Application for Prior Notification for Change of Use

DECISION NOTICE

Application Ref: BR/161/17/PD

Notification for prior approval under Part O for change of use from office (ClassB1(a)) to 14 No. residential apartments (Class C3)

PROPOSED FIRST FLOOR PLAN

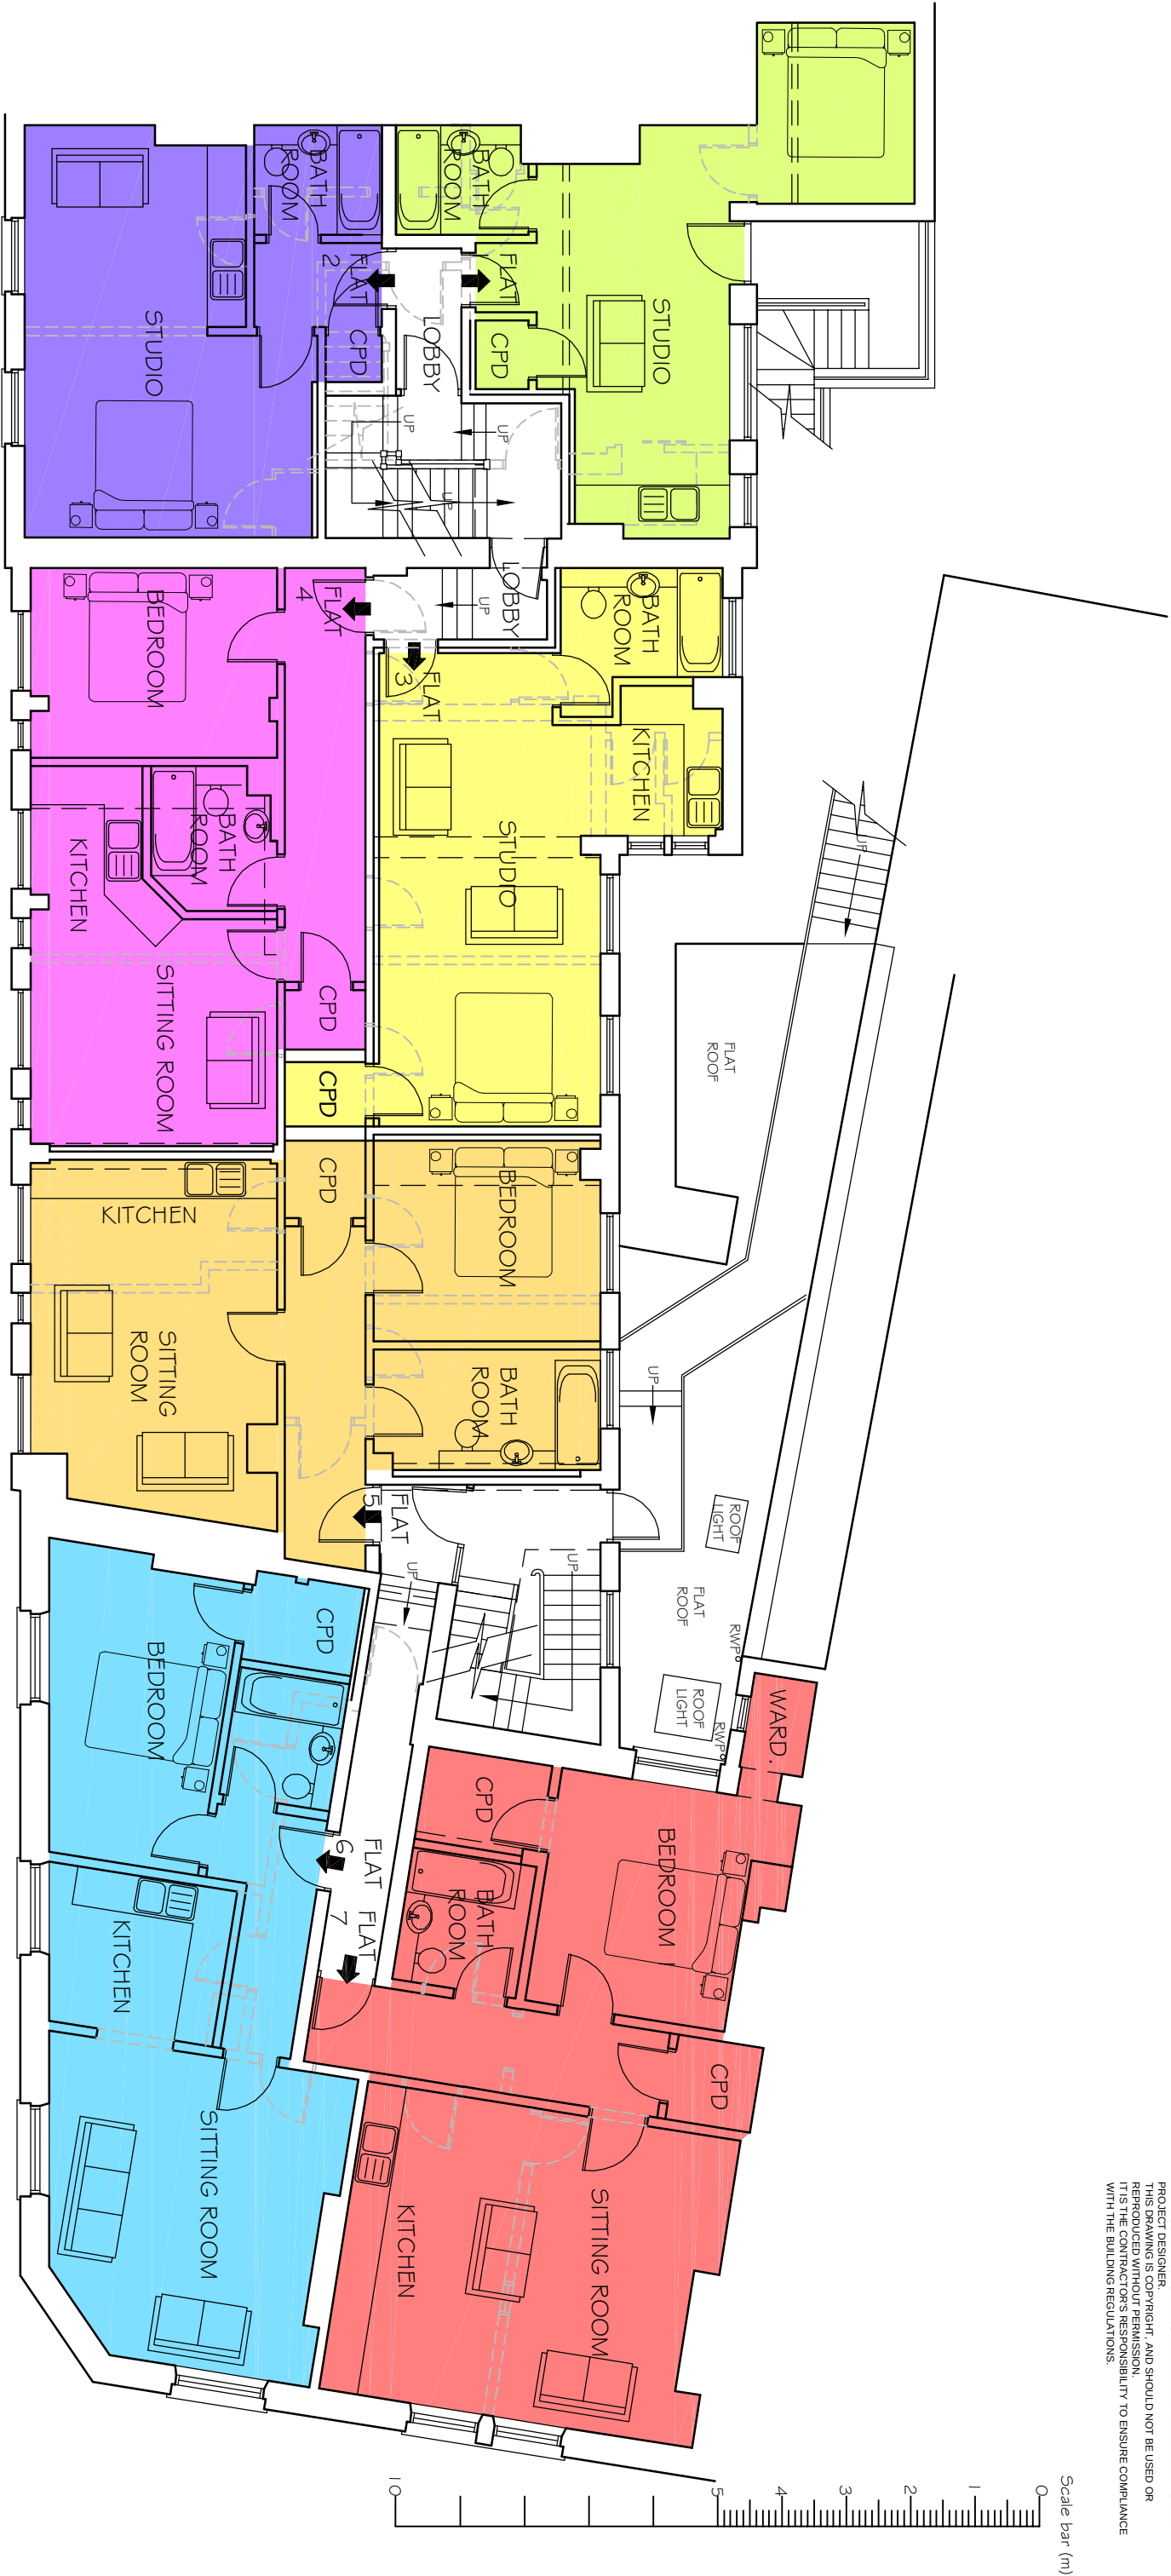
- The external staircase which is serving as a means of escape from the flats should be protected from the effects of fire along its length. The sensitive area is 1.8m horizontally therefore any windows in this region should be fire resisting construction and if possible fixed shut and any doors should be fire resisting and self-closing.

- A room where the only escape route is through another room is termed an "inner room" and poses a risk to its occupiers if a fire starts unnoticed in the outer room. The escape routes from the bedroom in the first floor studio flat is via the kitchen, this can be overcome by ensuring that an escape window is provided and adequate fire protection within the flat.

- Any bathrooms and kitchens without windows for natural ventilation should have adequate mechanical ventilation.
